From: Richard Temple
Sent: 28 February 2018 14:03
To: Planning.Responses
Subject: FW: 1 Regis House Bognor Regis BR/37/18/DOC

Registered: 07-FEB-18
Site Address: 1 Regis House Richmond Road Bognor Regis PO21 1BU
Description of Works: Application for approval of details reserved by condition imposed under planning permission BR/292/16/PL (Appeal ref. APP/C3810/W/17/3169745) relating to condition No. 2 2) Details of the head, sill, mullions, jambs & glazing of the replacement windows on the North East elevation

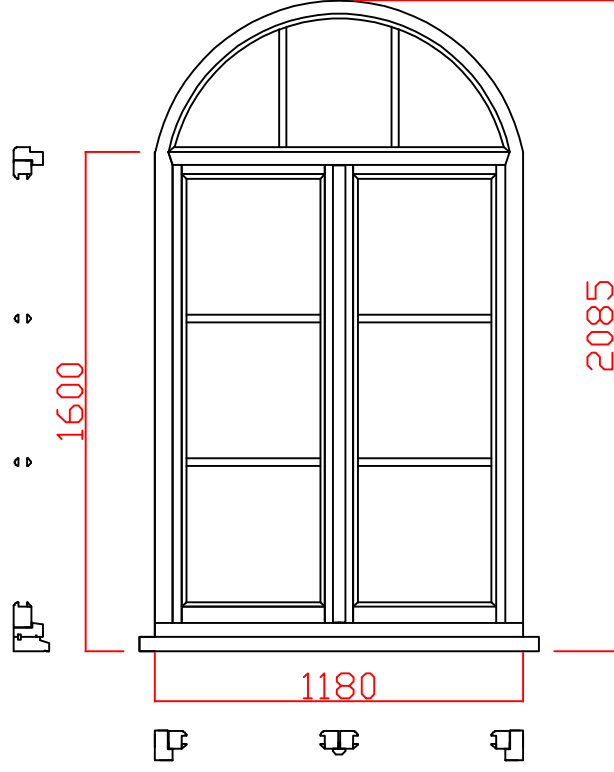
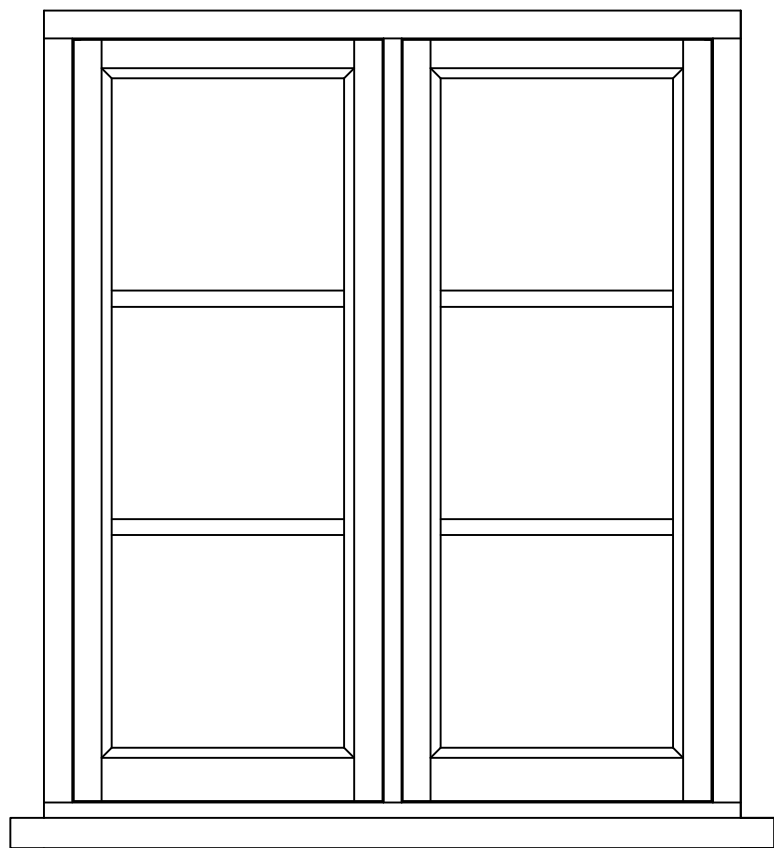
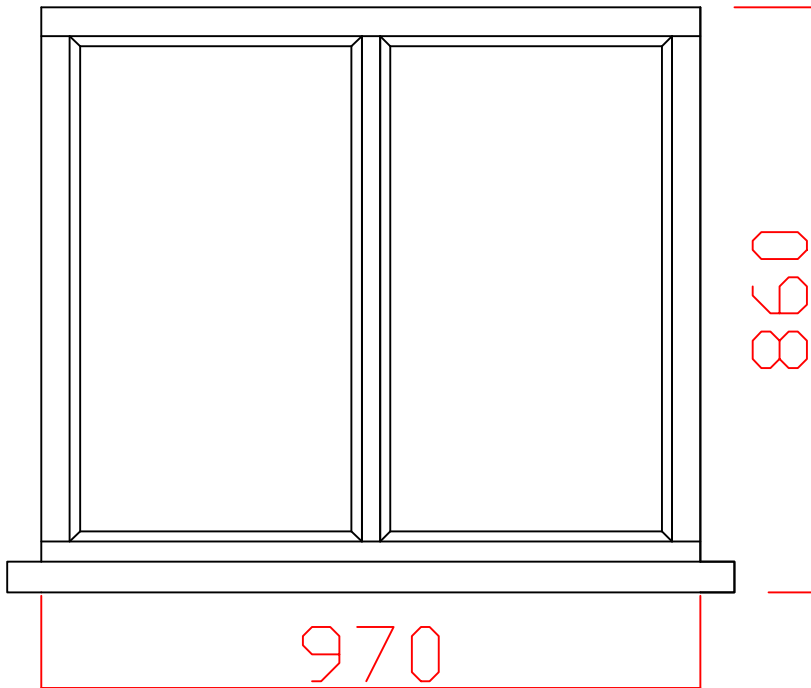
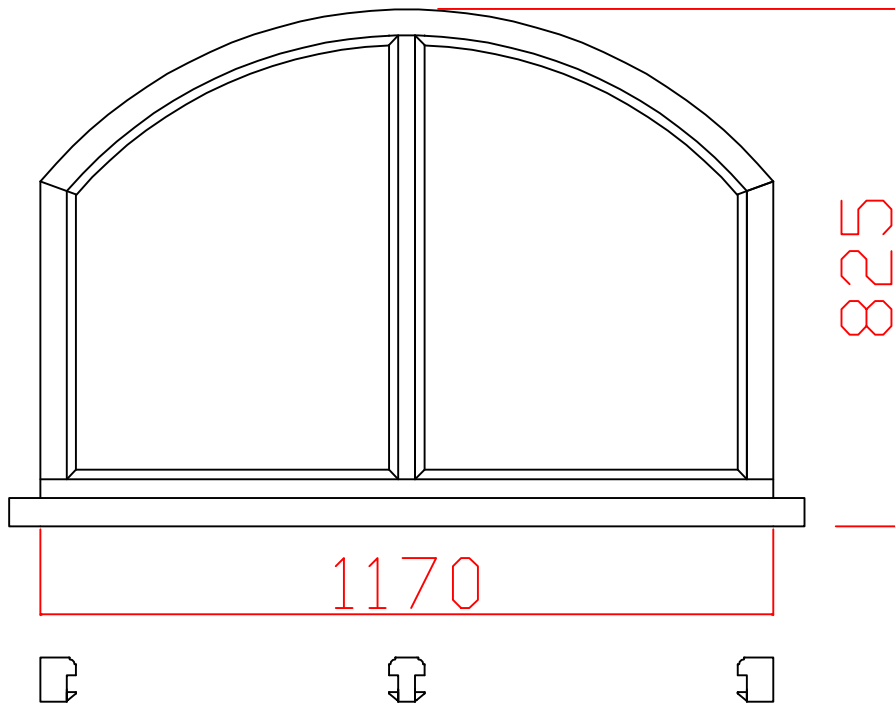
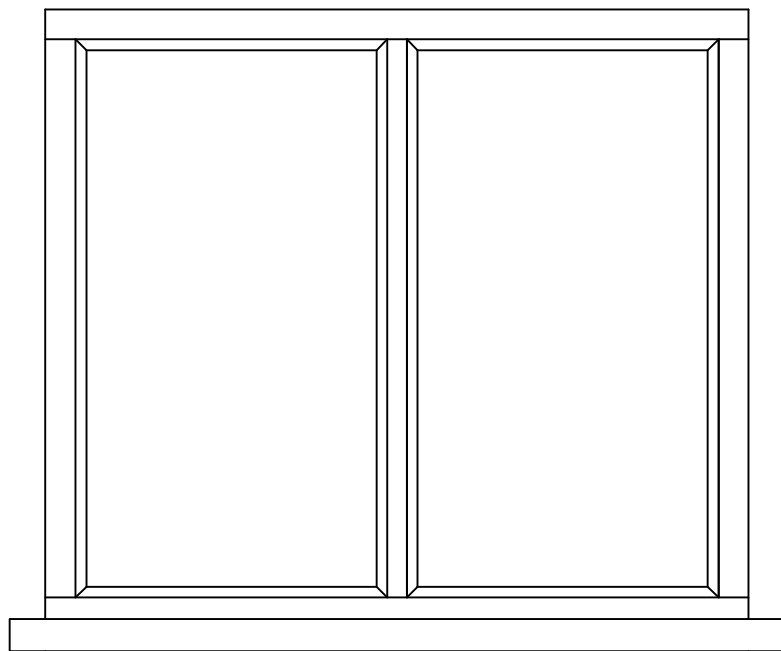
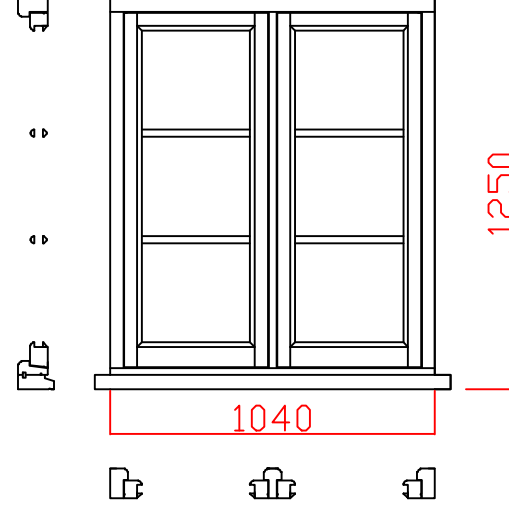
The submitted plans of joinery details are insufficient to provide comment. They are unscaled, and do not describe elements as set out in the Appeal Decision. It is also noted that no block plan has been submitted to locate the windows being replaced.
